COUNTY OF HARNETT RESIDENTIAL LAND USE APPLICATION

PROPERTY LOCATION: Subdivision: Woodshire Lot #: 224 Lot Size: 0.356

Re: Status of Improvement Permit Application #08-5-19310 – Lt 224
#08-5-19311 – Lt 225

— PLOT PLAN FOR —
CAVINESS LAND
— SUBDIVISION —
WOODSHIRE SUBDIVISION—PHASE FIVE

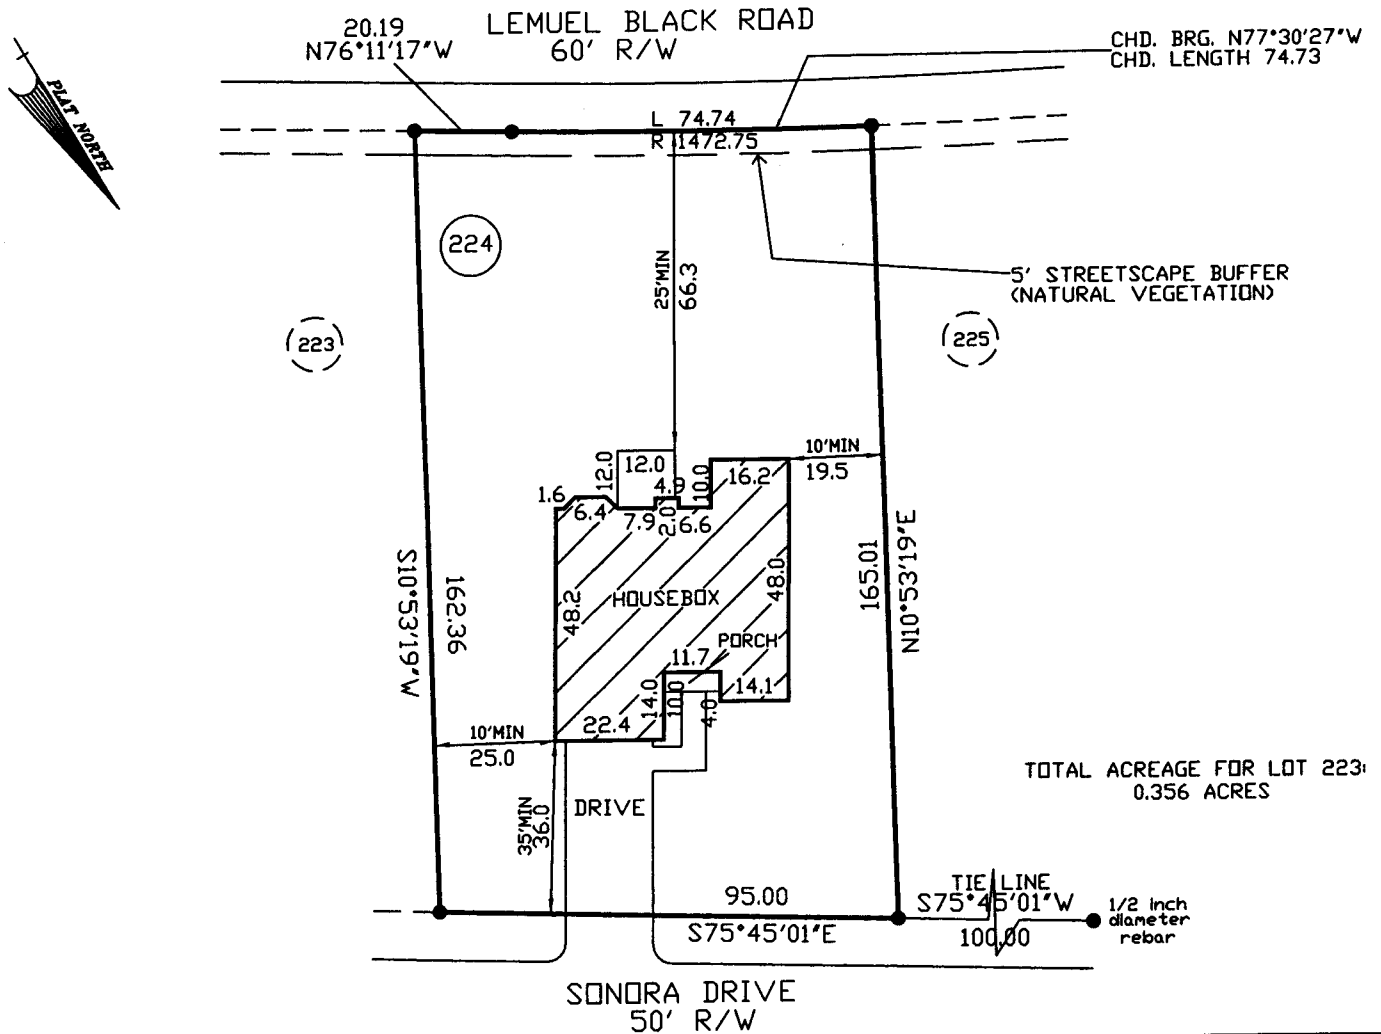
1. Property lines/corners not marked or labeled
2. House corners not marked or labeled
3. Directions not clear to property
4. Property needs brush or vegetation removed
5. Backhoe pits required
6. Other – Please move houses as shown and reduce to 3 bedrooms. Submit new plot plan to Central Permitting. (See attached)

Sh. of
House
As shown
And reduce
to 3 Bed room
for each
